Your Reference: MP10_0007 MOD 2 & 10_0008
MOD 2
Our Reference: RDC 10M287 - SYD10/00832
Contact: Stella Qu
Telephone: 8849 2520

**EXHIBITION OF MODIFICATION REQUEST FOR HOXTON PARK INDUSTRIAL
PROJECT**

I refer to your correspondence dated 23 November 2010 (MP10_0007 MOD2/10_0008 MOD2) regarding the proposed modifications to the concept plan approval for the Hoxton Park Industrial Estate on Cowpasture Road, which was referred to the Roads and Traffic Authority (RTA) for comment.

**Figure 12** – Proposed basin location

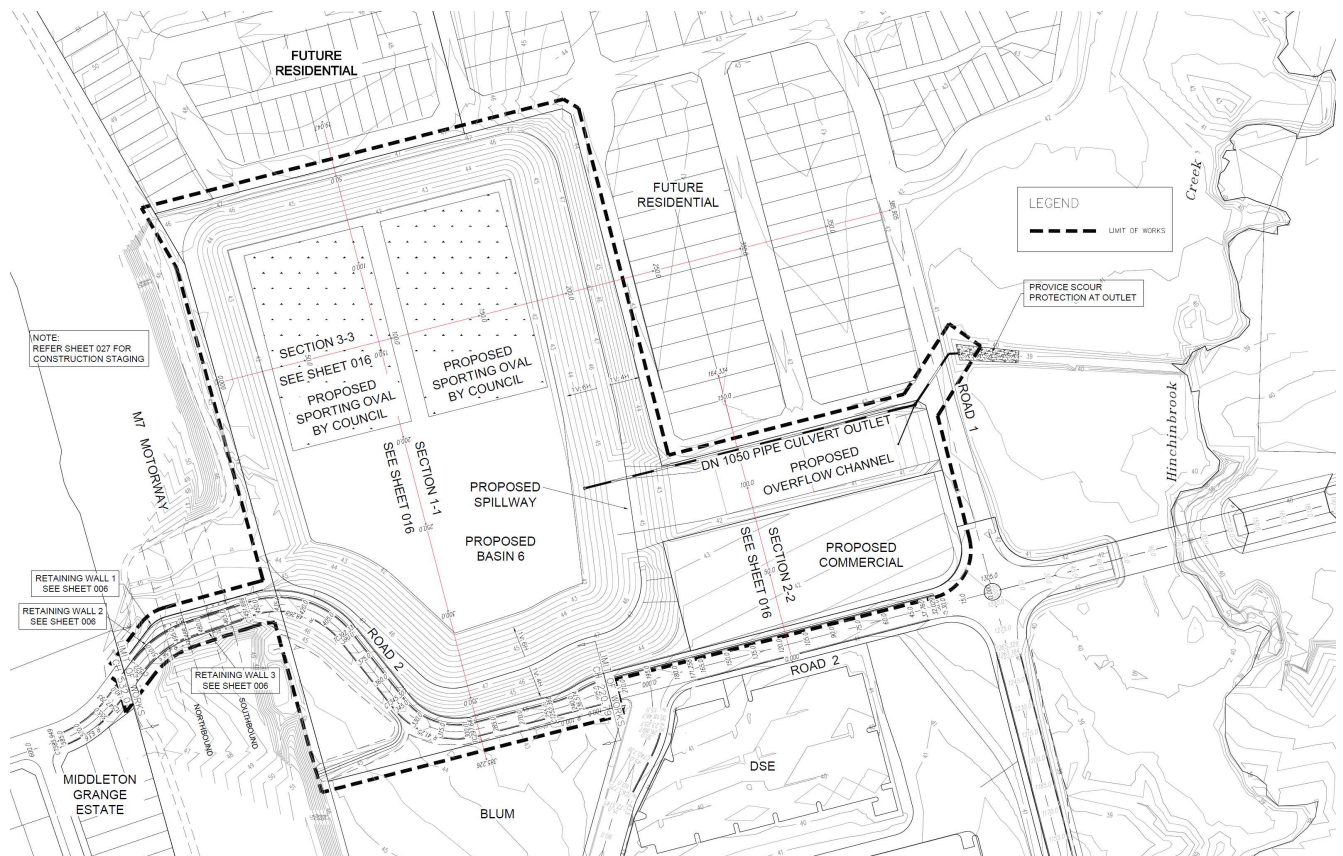
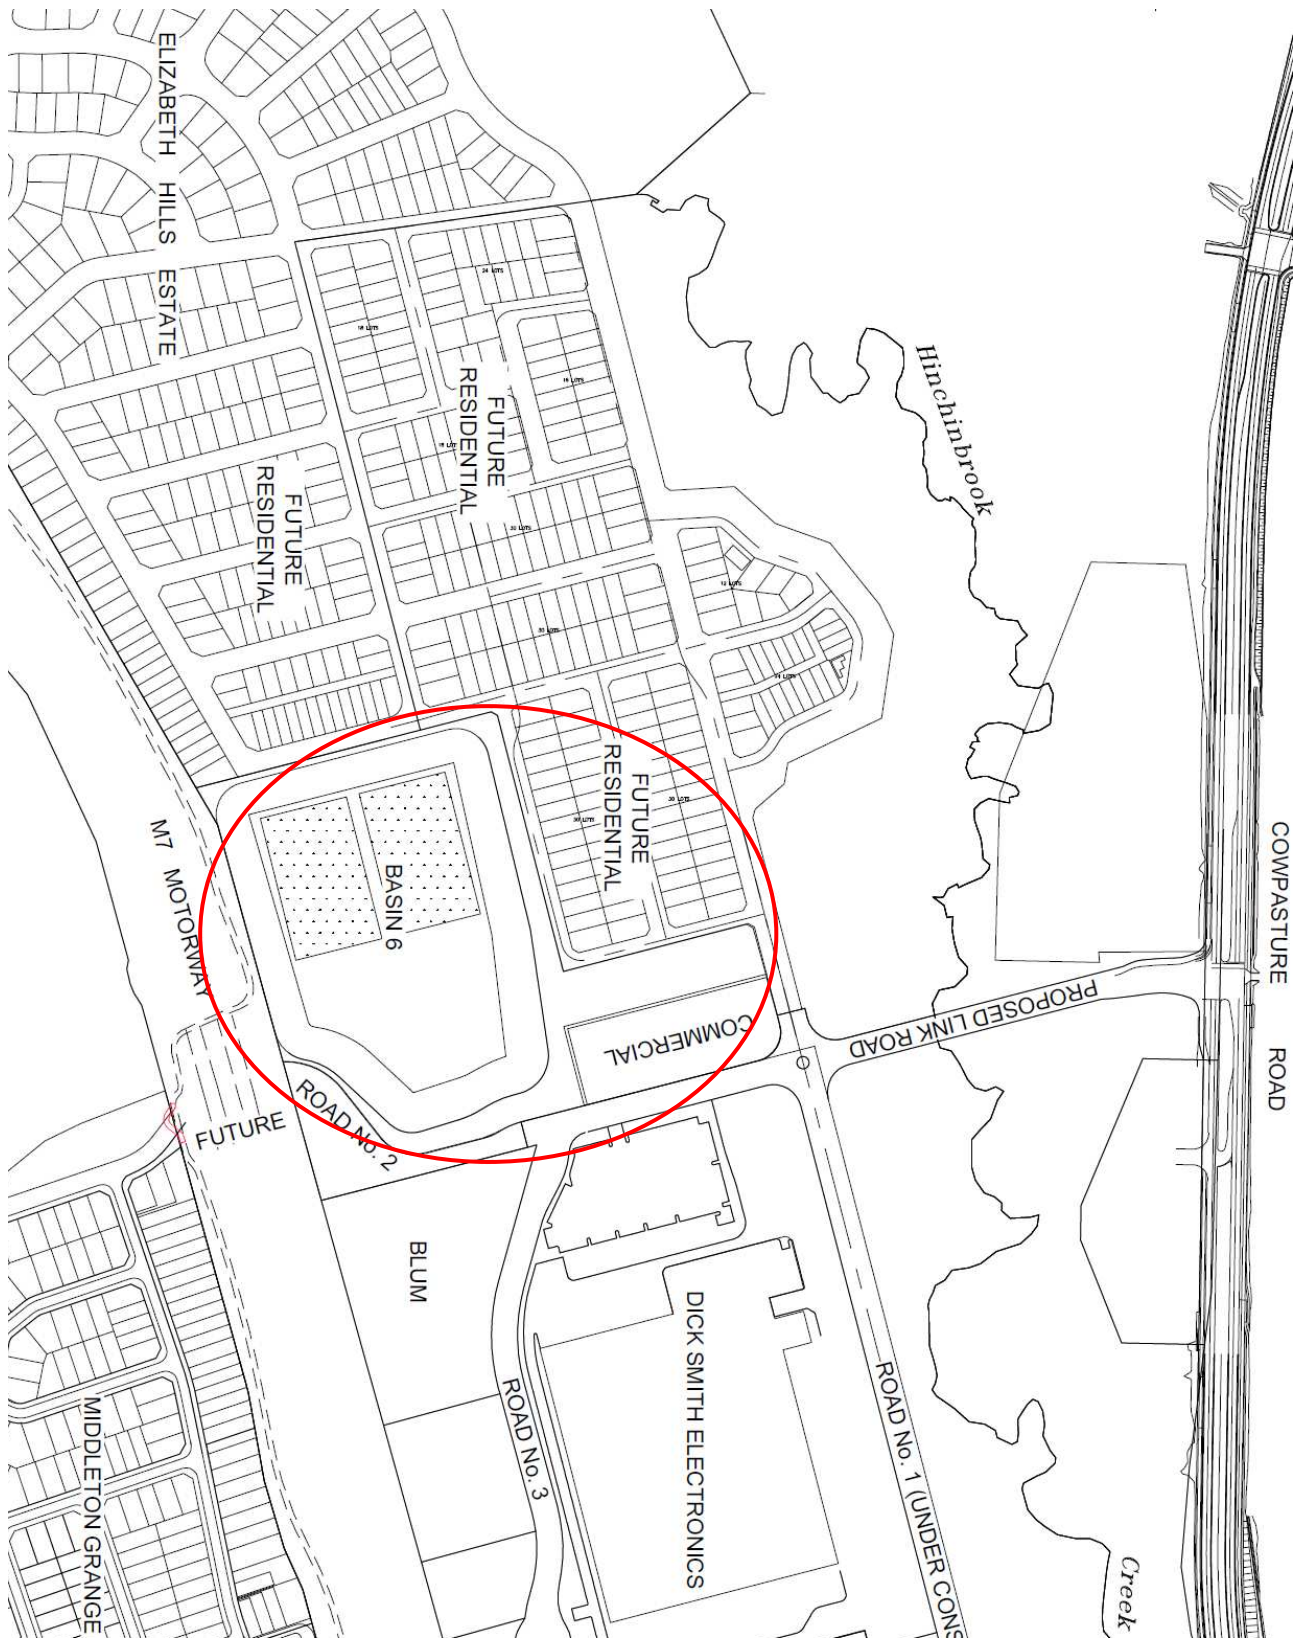
The RTA has reviewed the proposed modifications and raises no objection subject to the developer providing structural advice (to RTA's satisfaction) regarding the M7 bridge piles in the vicinity of the new underpass, prior to the Principal Certifying Authority issuing a Construction Certificate for the Basin 6 works.
